5 December 2017

File No: R/2016/6/A
Our Ref: 2017/608299

Ultimo Pyrmont Public School, 47-53 Jones Street, Ultimo (SSD 7503)

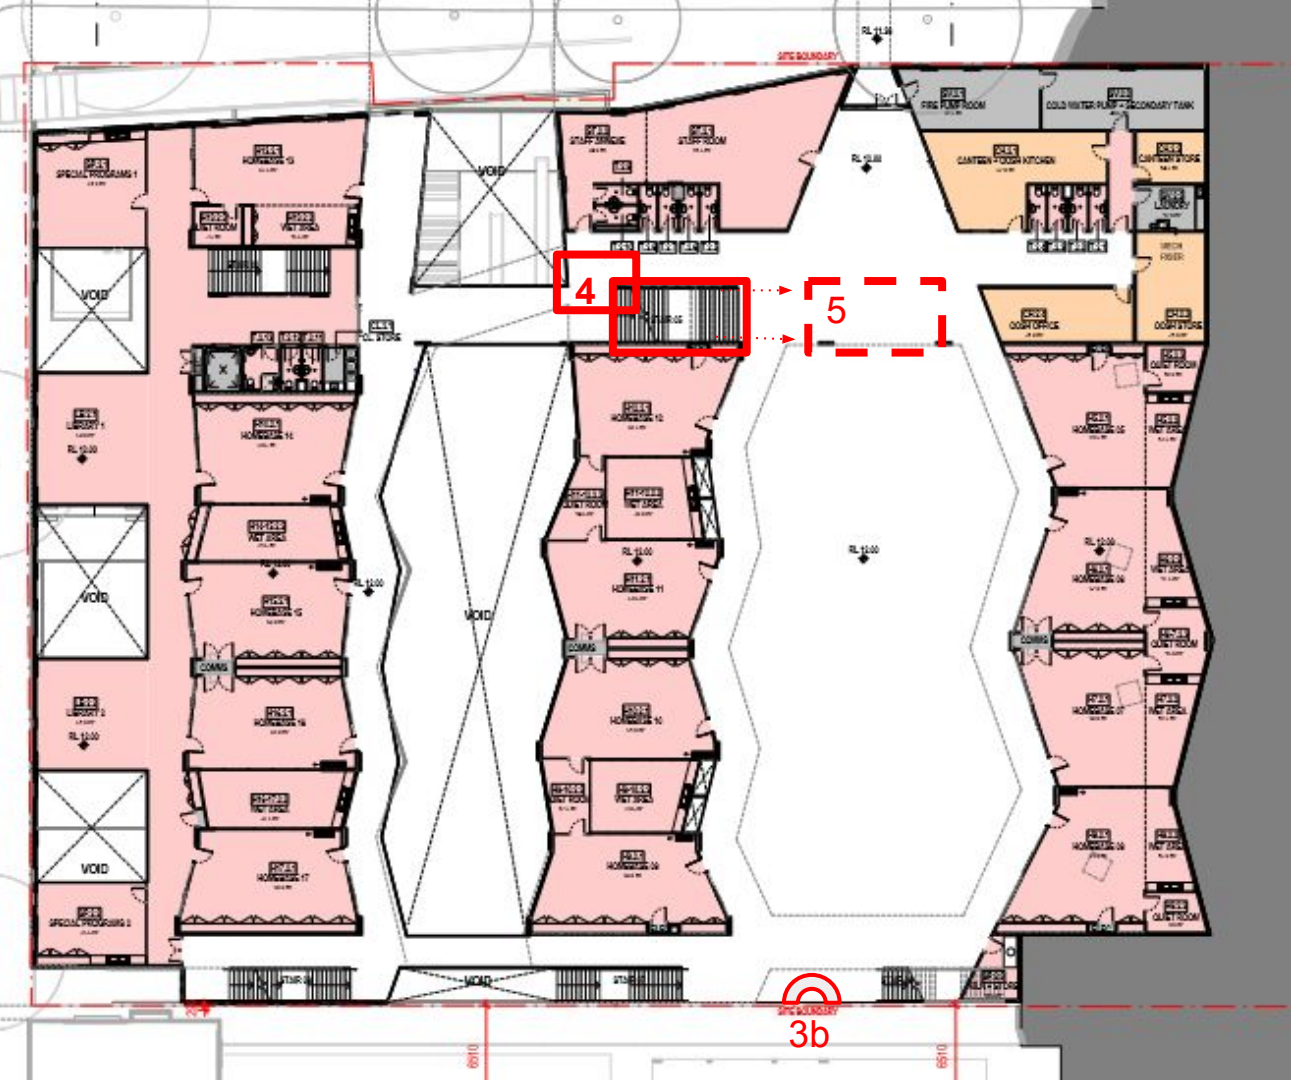
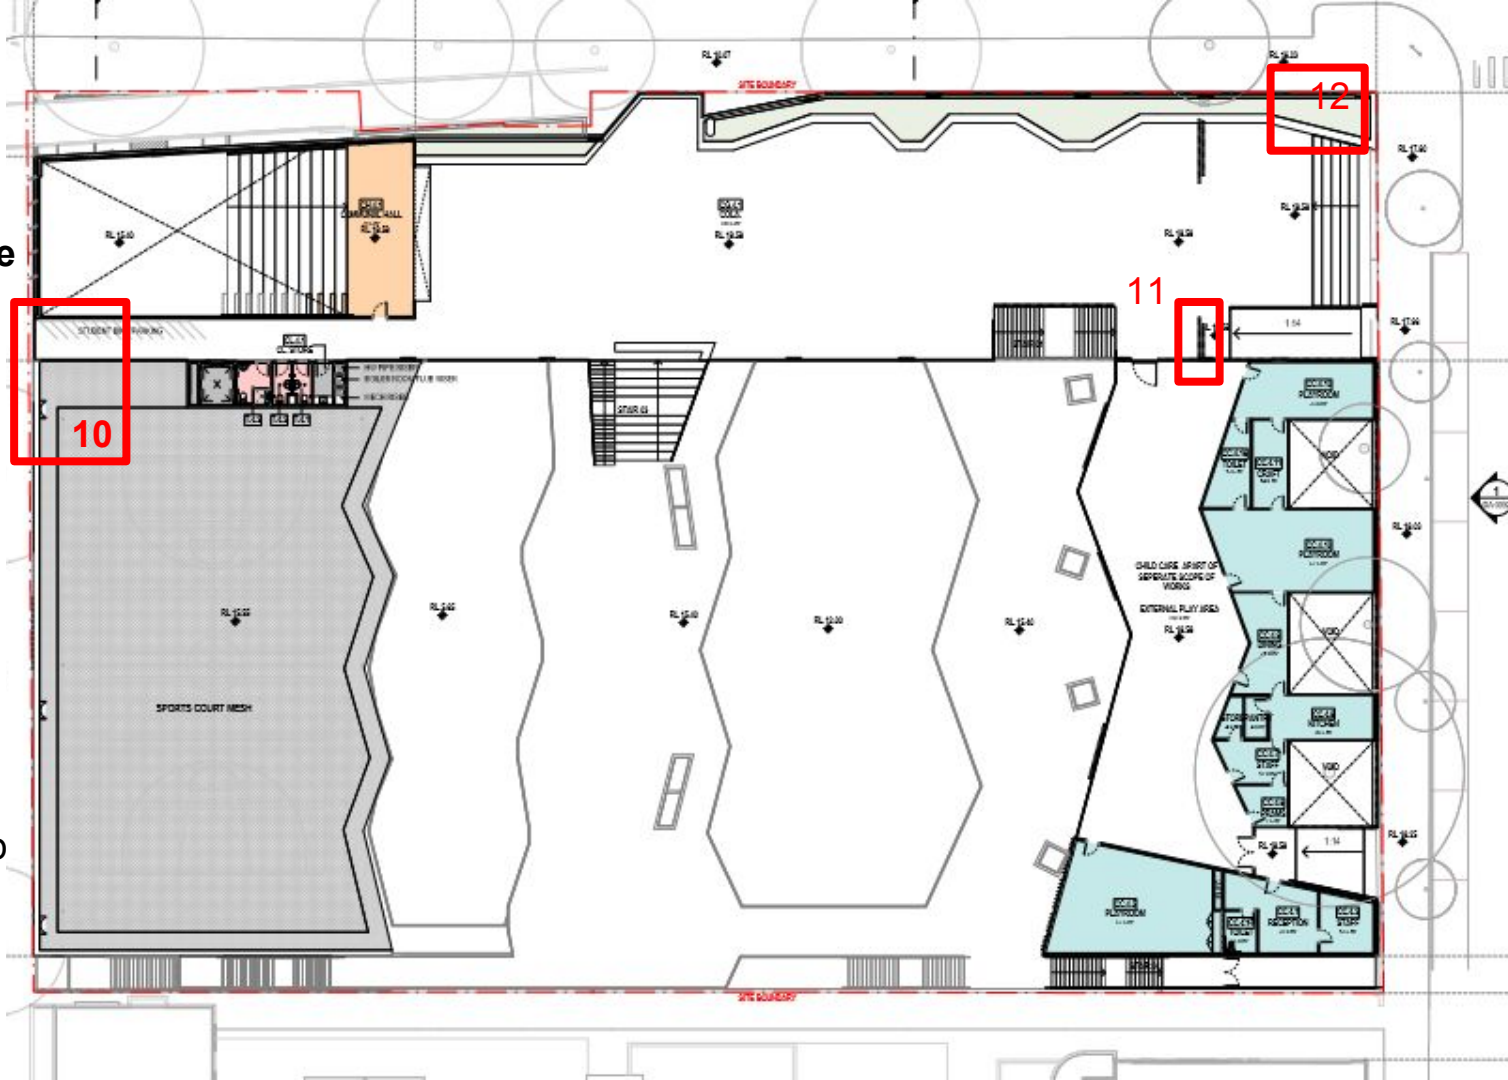
- A covered space beneath the Wattle Street pedestrian bridge adjacent to the gas meter assembly is identified on Ground-Lower Playground plan on drawing DA-2300 that provides opportunities for concealment. It would be preferable to enclose this space at the line of the street boundary to remove improve safety and security concerns.
- The same issue occurs again at Level 02-Middle Playground level adjacent to the Fire Pump Room on the northern boundary. Again, the line of enclosure should be brought to the street boundary to remove the void area formed by the inverse angles to this space. Alternatively, if a void space is required at the interface with the footpath, the angles of the side walls to this space should be reversed, to remove concealed areas and to improve safety and security.

- The same issue occurs again at Level 3- Upper Playground level adjacent to the admin entry, and at Level 4, where the eastern entry to the stair on the southern boundary is recessed significantly. To remove safety issues, the line of the gates should be brought closer to Jones Street.
